Please ask for: Mrs D Johnson
Email: daun.johnson@arun.gov.uk
Telephone: 01903 737762
Our Ref: AB/46/22/A
Your Ref:
Date: 22nd April 2022

Town & Country Planning (Control of Advertisement) (England) Regulations 2007 (as amended)

Application for Consent to Display an Advertisement(s)

Development: Installation of 1 No externally lit hanging sign and 1 No externally lit informative sign on front elevation.
Location: 2 Maltravers Street Arundel BN18 9AP

DATE: APRIL 2022
SCALE: 1:50 @ A3
JOB No. 1131
DRWG No. 120 Rev./

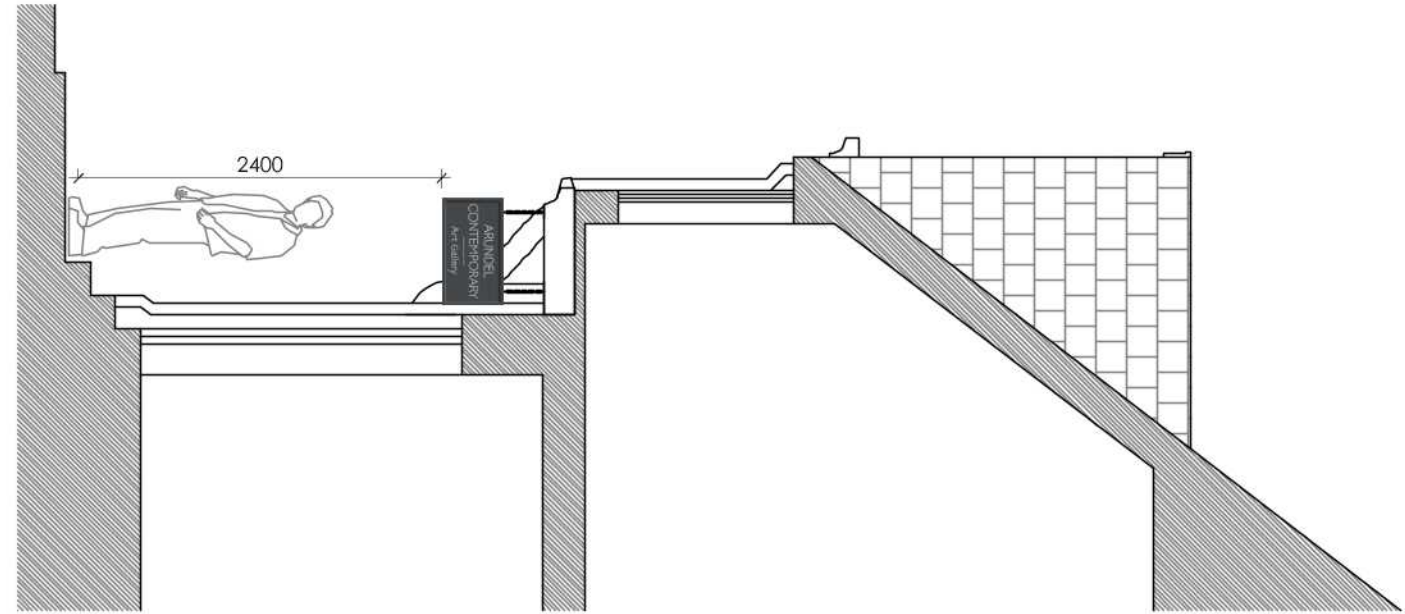
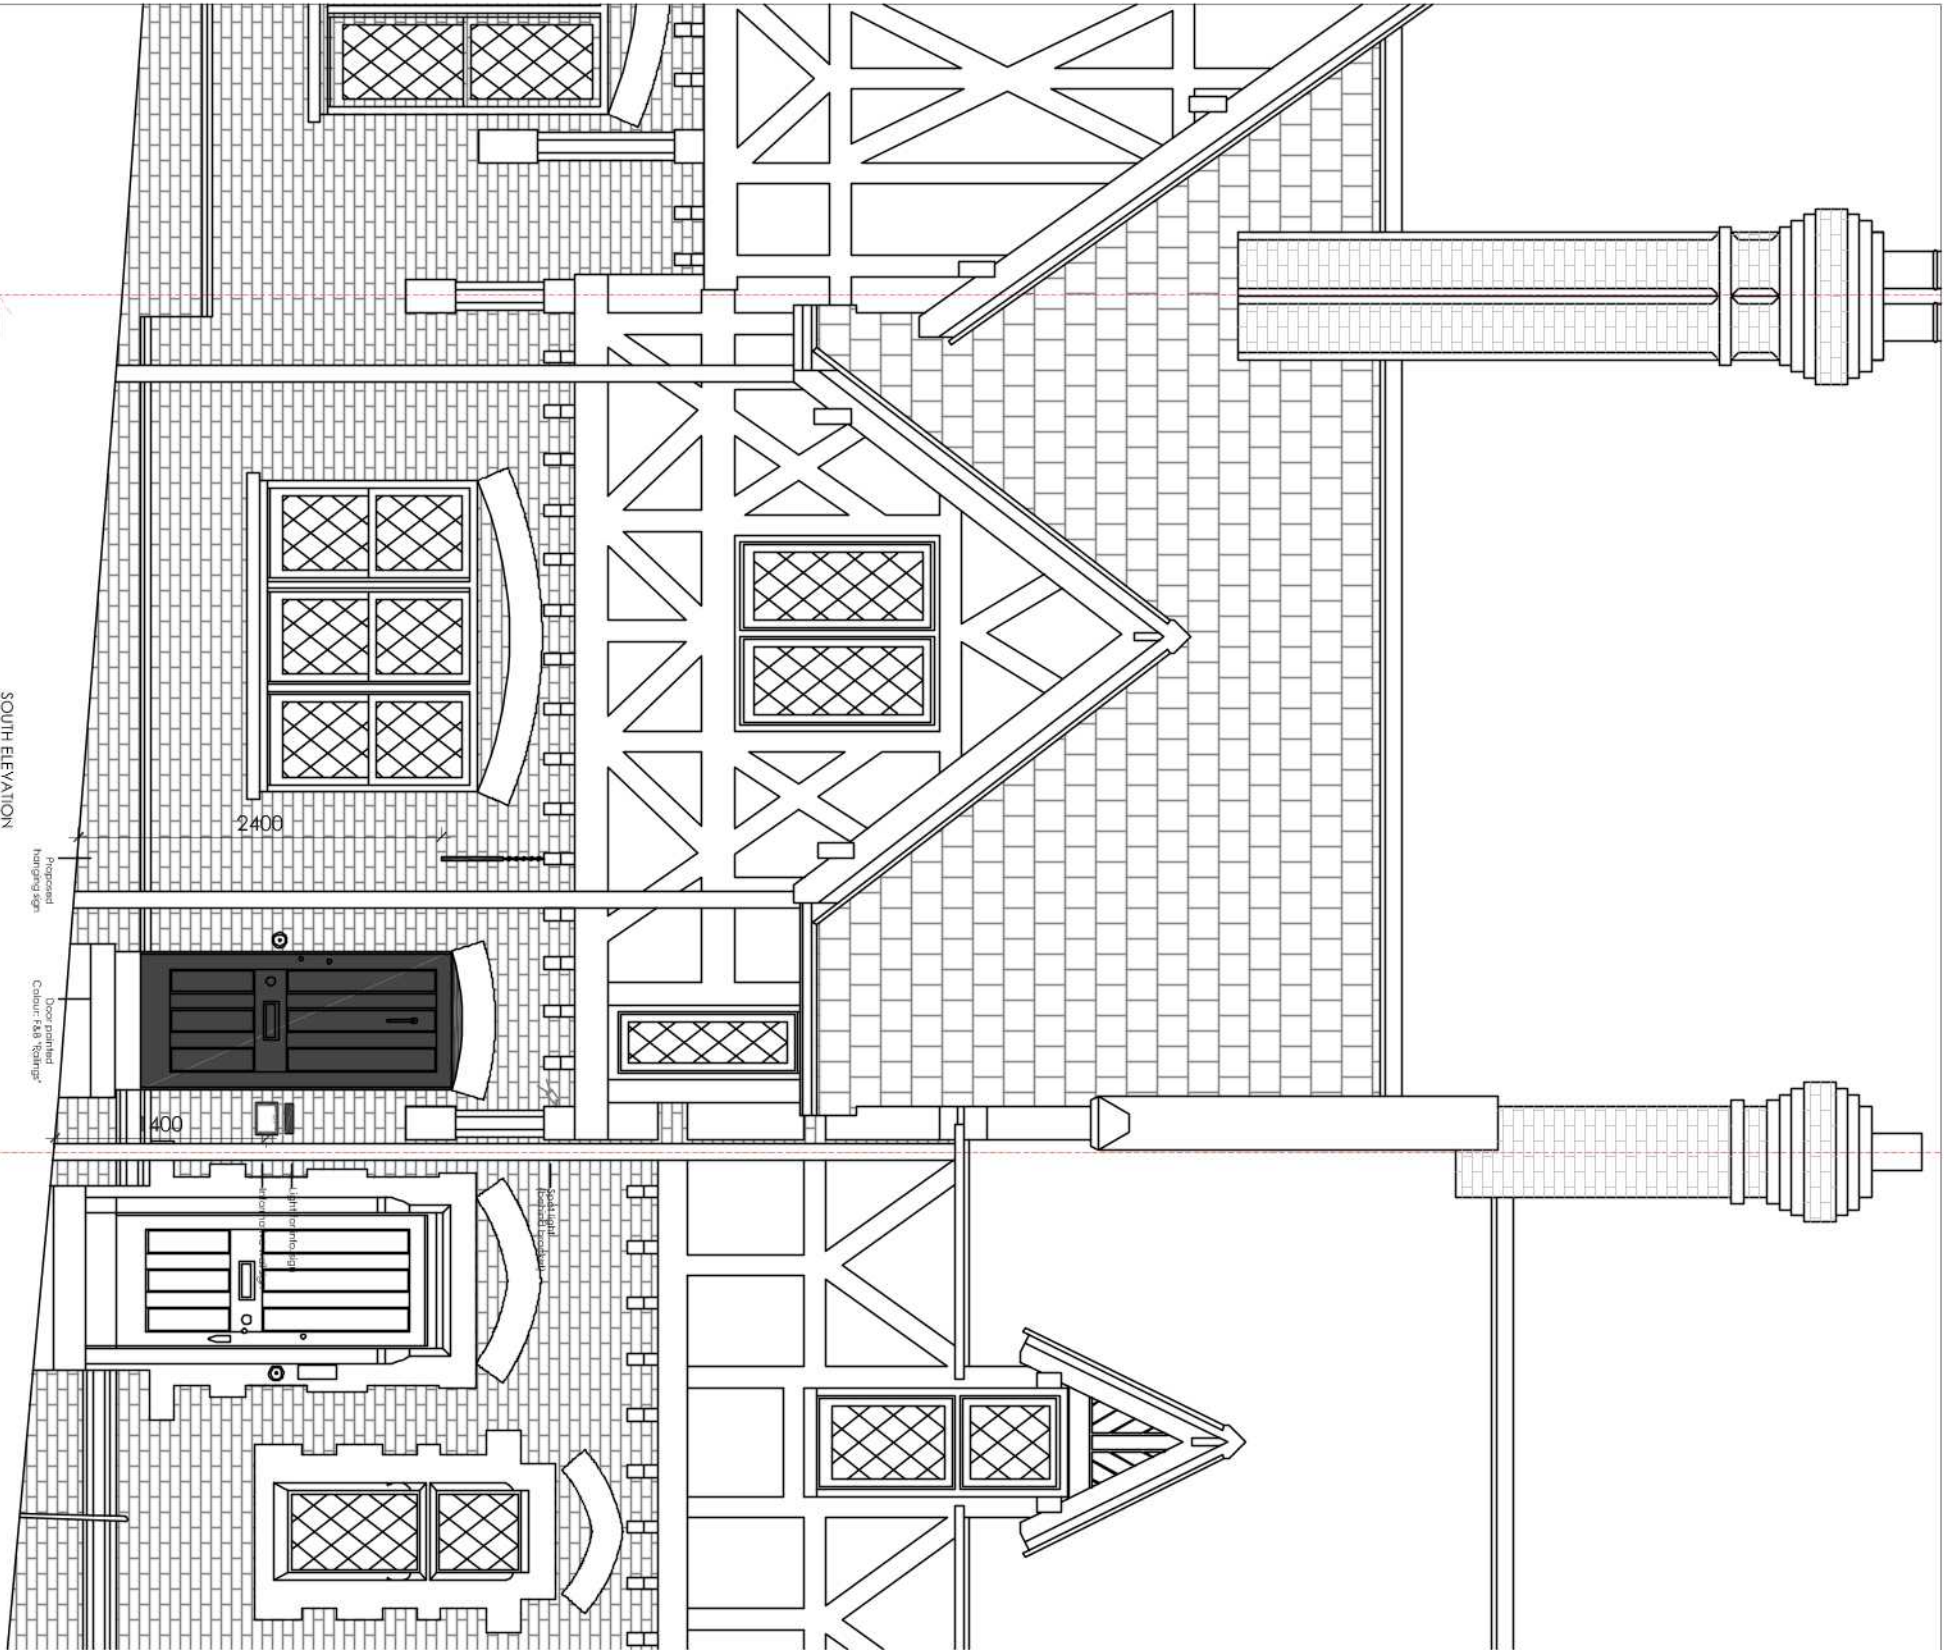
On plan 120, the legend says proposed elevation and side view but the lower left corner says existing. Please clarify.
